## **DEPARTMENT OF PUBLIC WORKS**

Jan. 24, 2017

### **County Survey review of Crowley Proposed BLA**

**CROWLEY PROPERTY**

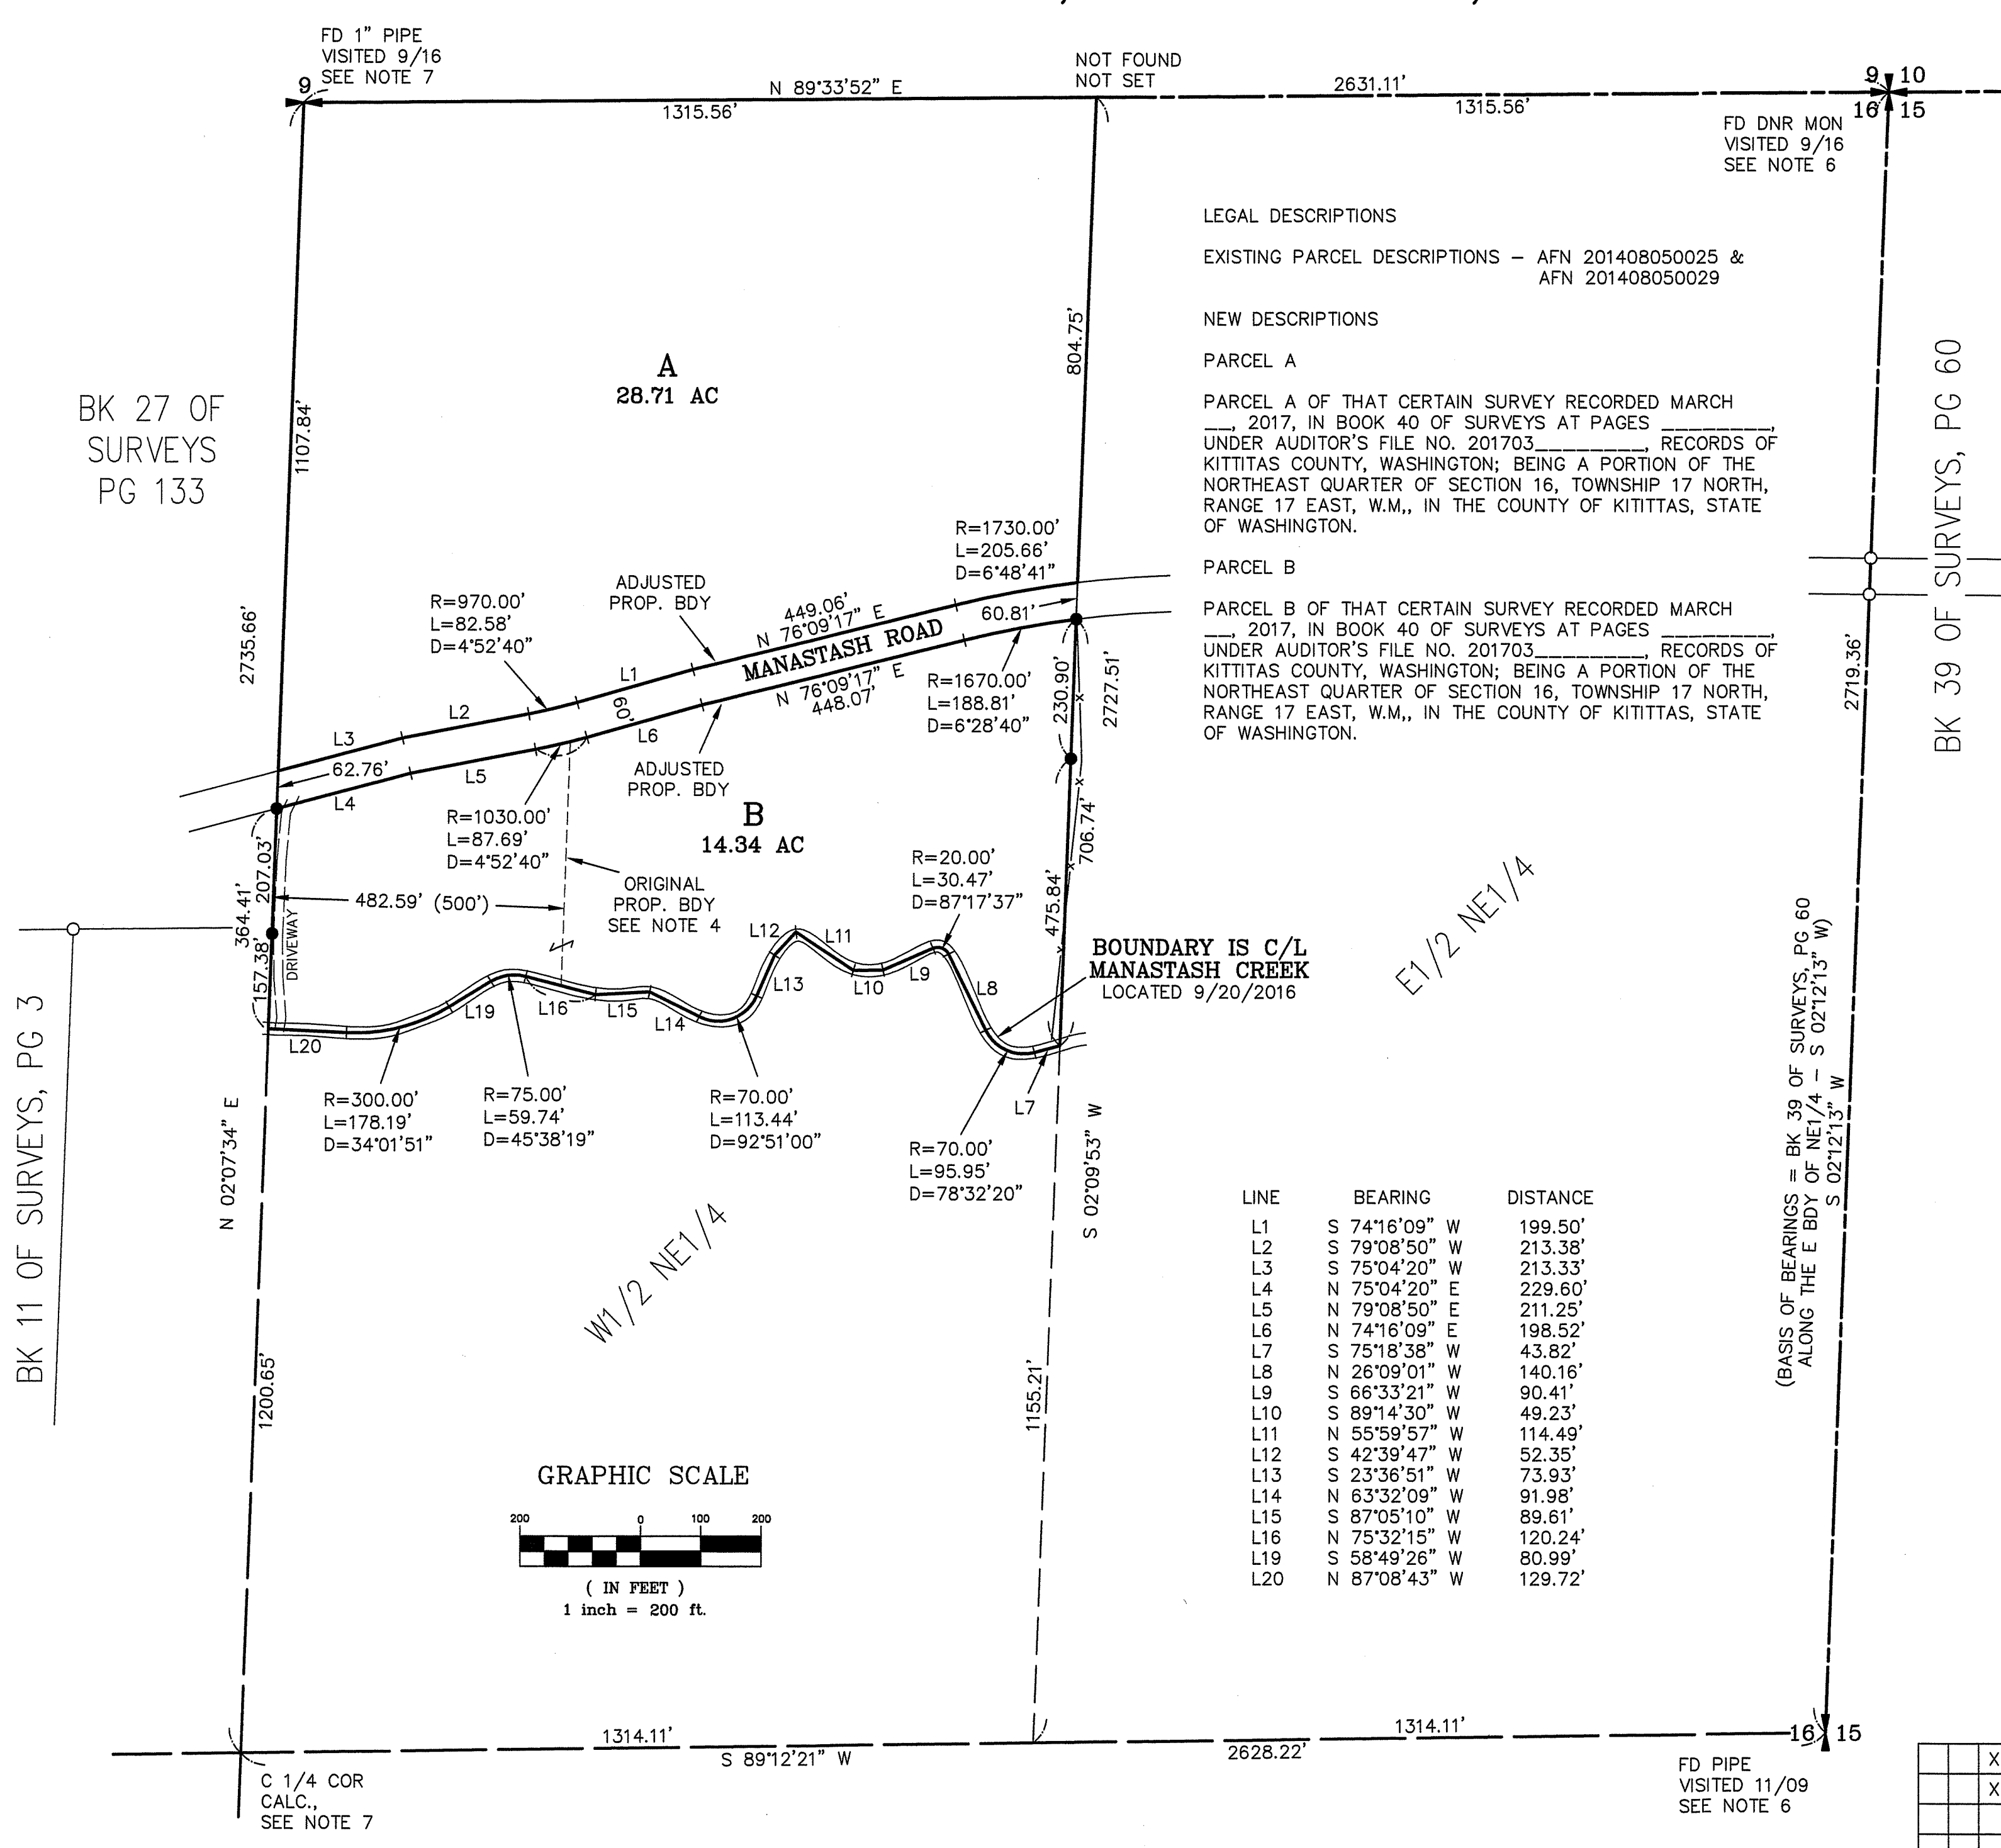
CDS expressed some concern regarding ownership of Manastash Rd. It is a county road as shown on the Proposed BLA. Mr. Cruse has identified that a previous survey did not except out the road, and this is reflected in the notes.

CDS expressed some concern regarding the existing and proposed boundaries. I believe this confusion is a result of Mr. Cruse identifying the current "existing boundary", rather than a proposed "previous boundary". I see no problems with the proposed lot layout.

The resultant Lot A falls entirely on a hillside with an average cross slope of 40%. If possible, I would have CDS make a statement that approval of the BLA does not make any sort of guarantee of a buildable parcel.
